**KIRKLEES METROPOLITAN COUNCIL
INVESTMENT & REGENERATION SERVICE**

DELEGATED DECISION TO DETERMINE PLANNING APPLICATIONS

Reference No:	2023/62/91795/E
Site Address:	2, Enfield Drive, Carlinghow, Batley, WF17 8DY
Description:	Erection of two storey side extension and new porch with associated alterations
Recommending Officer:	Nicole Helliwell

Officer Report

GROUND FLOOR

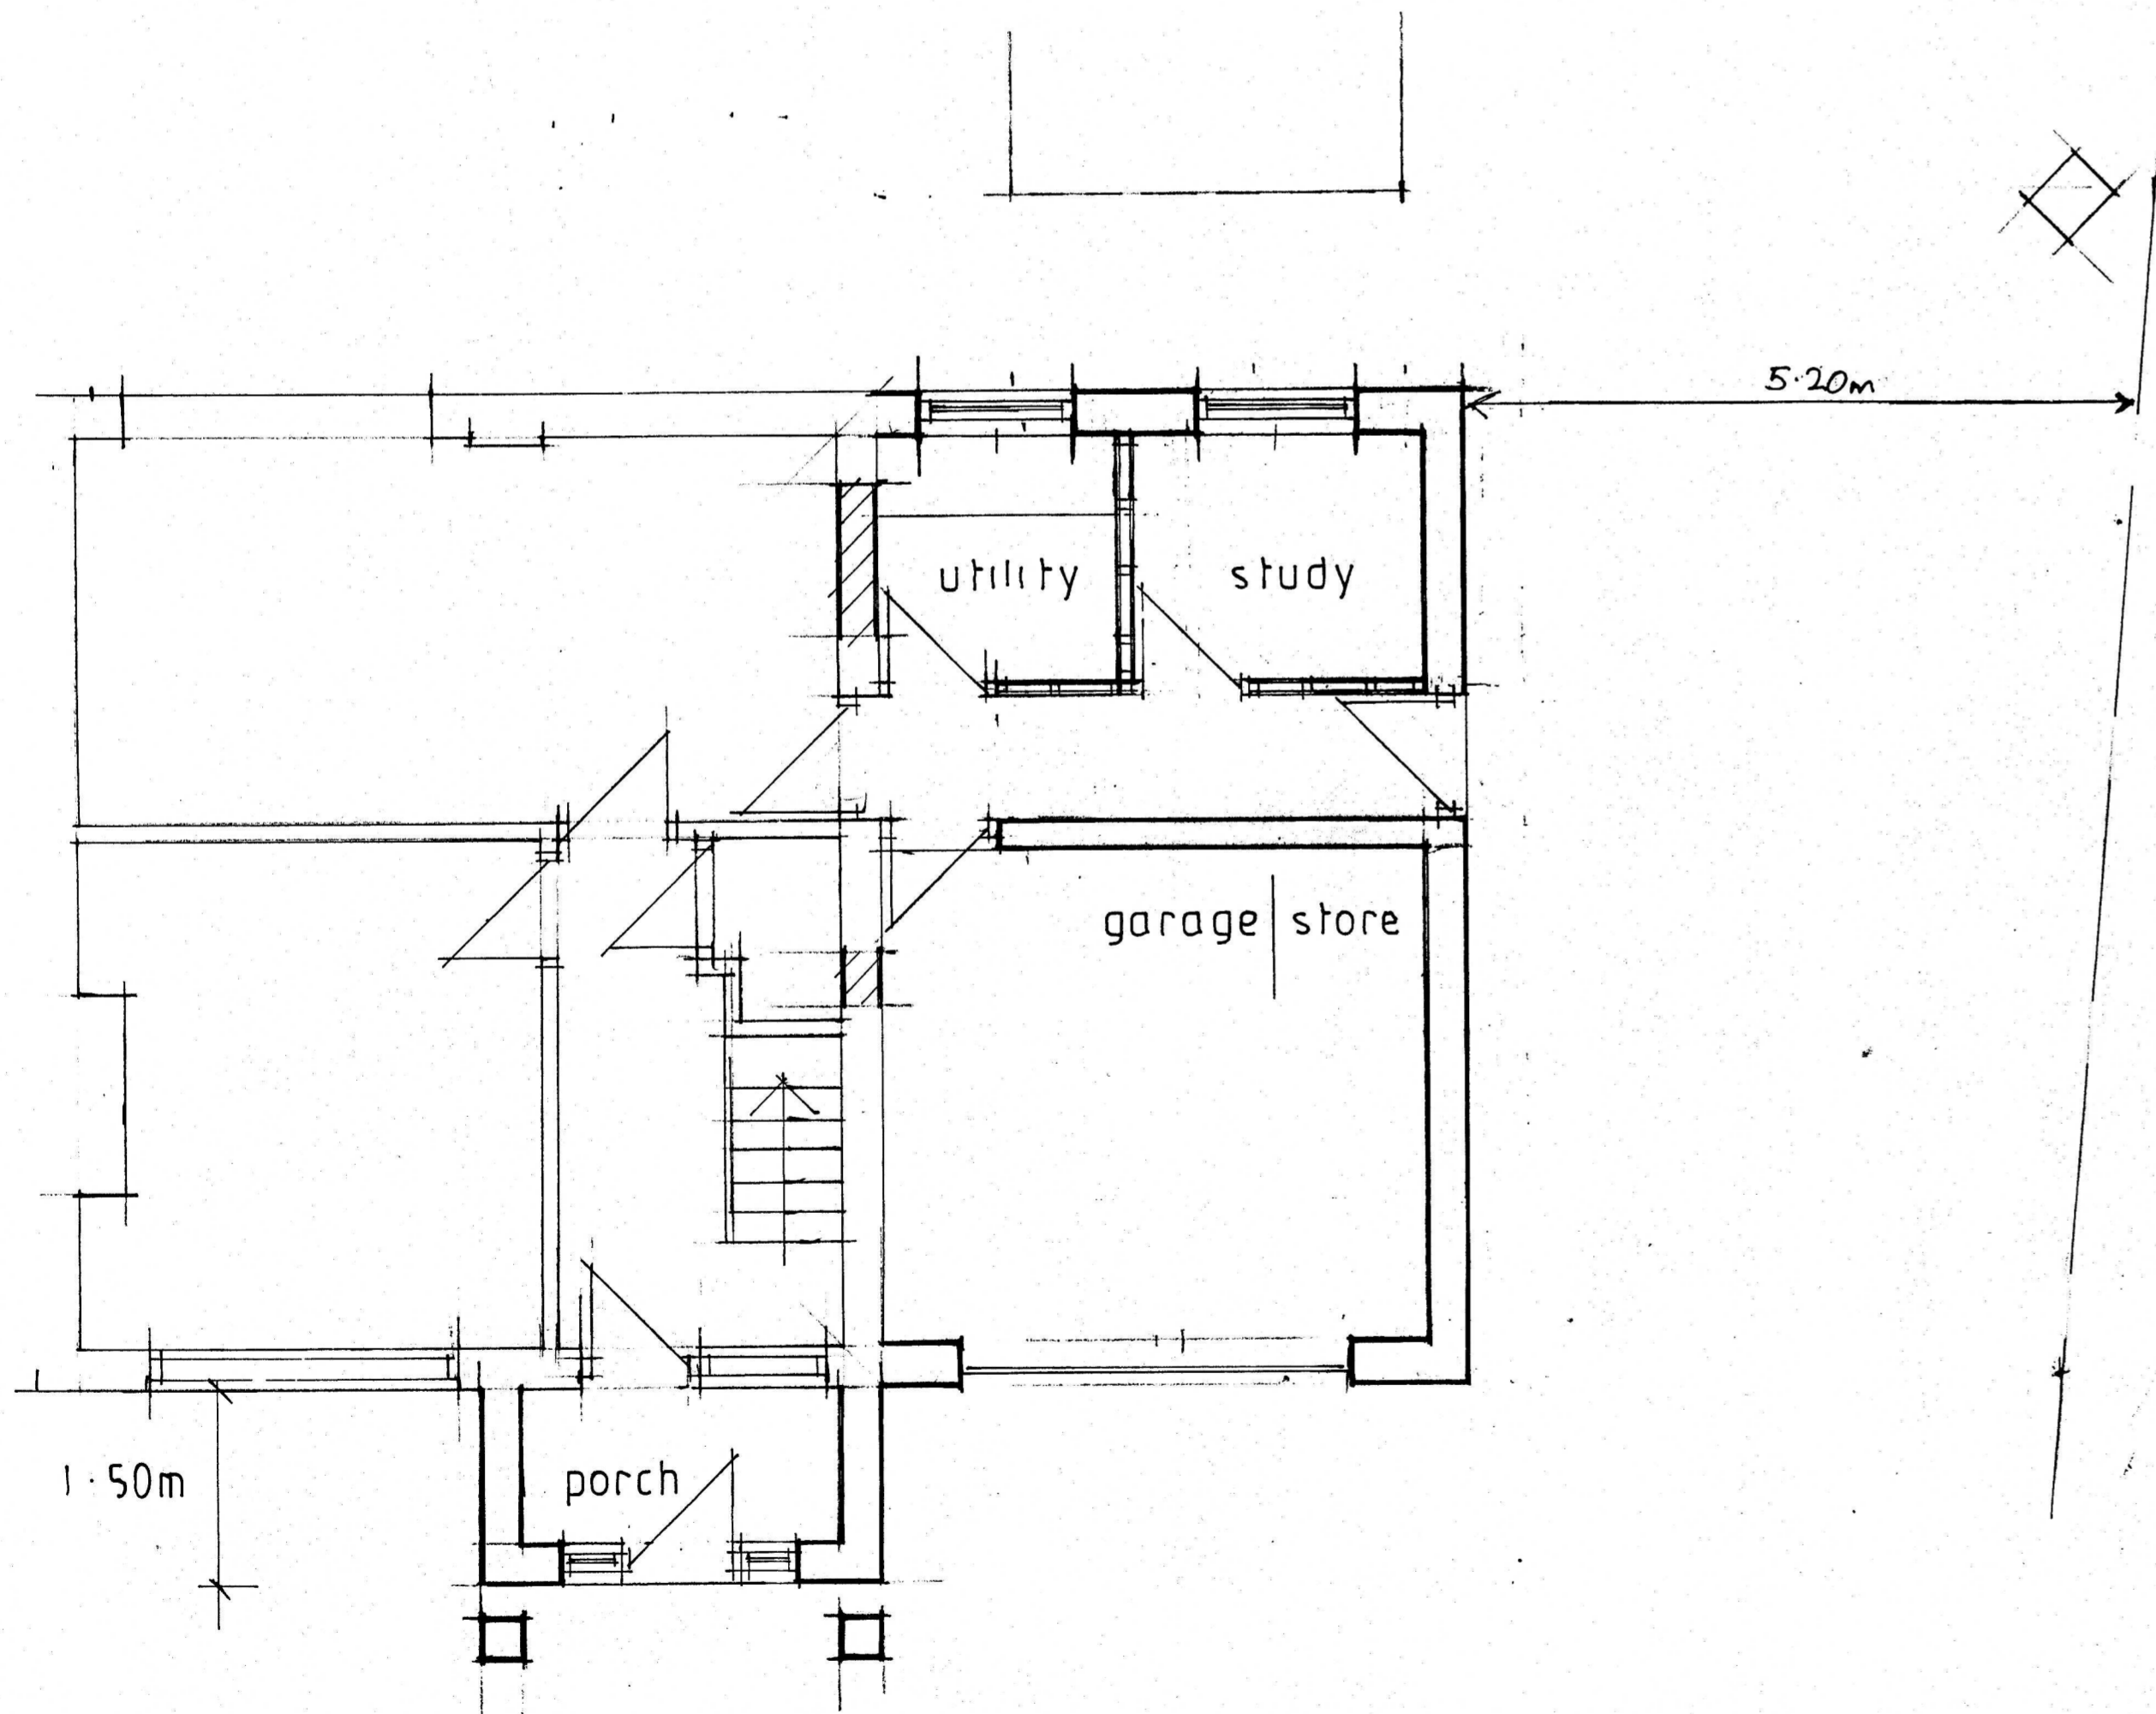
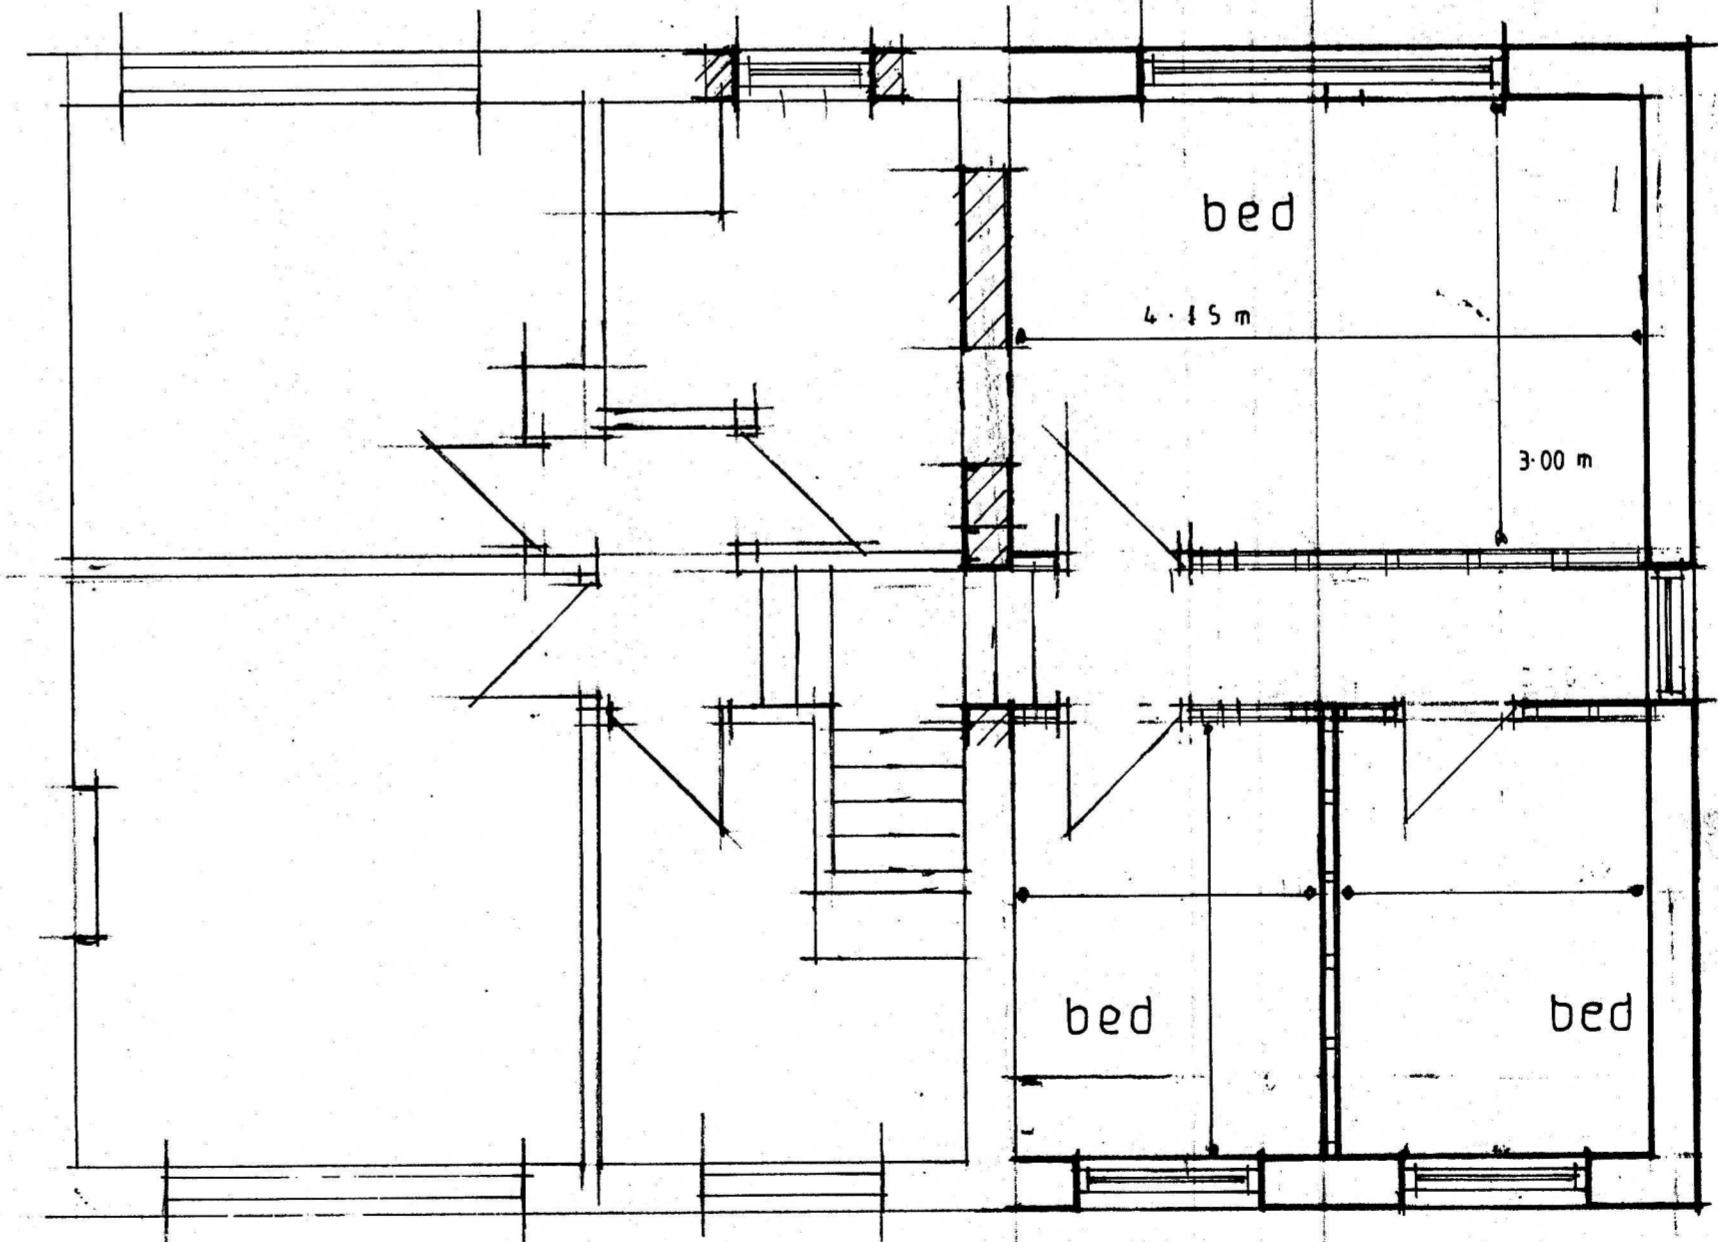
The proposed two storey extension would project approximately 4.5m from the side elevation of the original dwellinghouse. The enlargement would be faced in pebble dashed render and would incorporate a dual pitched roof finished in concrete tiles to match the appearance of the host property. Although the extension would be flush with the principal elevation and would feature a comparable ridge line to that of the host dwelling, given that the property occupies an end plot of an ample size, the extension would maintain a sense of space and would appear subservient in relation to the host property. Whilst it is noted that the enlargement would alter the scale and form of the original build, it would not represent an incongruous or unduly prominent feature or amount to overdevelopment. Furthermore, the plans confirm that the extension would retain at least a 1m gap to all property boundaries and would not give rise to any terracing effect. Therefore, it is considered that on balance, in this instance, the proposal would not have

The proposed canopy would extend approximately 0.6m from the front elevation of the proposed porch extension. Whilst it is acknowledged that front canopies are not a common feature within the street scene, it is noted that the structure would have a modest scale and would appear subservient to the original build. Furthermore, the canopy would be set back from the pavement and would not appear overly prominent from public vantage points. Therefore, it is considered that the proposed development would be acceptable in terms of visual amenity.

4 Enfield Drive is a residential property located west of the application site. The submitted plans confirm that the proposed front porch would be positioned approximately 3m away from the common boundary shared with no.4 and would accord with the 45-degree rule in relation to the neighbour's ground floor fenestration. Furthermore, the proposed two storey side extension would be positioned east of the host property and would not project forward of the neighbour's front or rear elevations. Therefore, due to its siting, it is considered that there would be no undue harm to the neighbouring occupants with regard to overlooking, overshadowing and overbearing impact.

Amendments were sought during the course of the application. A request was made to reduce the projection of the proposed two storey side extension, set it down from the existing ridge line and back from principal elevation in line with the House Extensions and Alterations SPD. Although the revised drawings submitted did not address all of the concerns raised, the agent did provide full justification as to why the proposed development would be acceptable. Therefore, on balance it is considered that the design of the proposed two storey extension would be appropriate from a visual amenity perspective (this is expanded upon in the visual amenity section of the report).
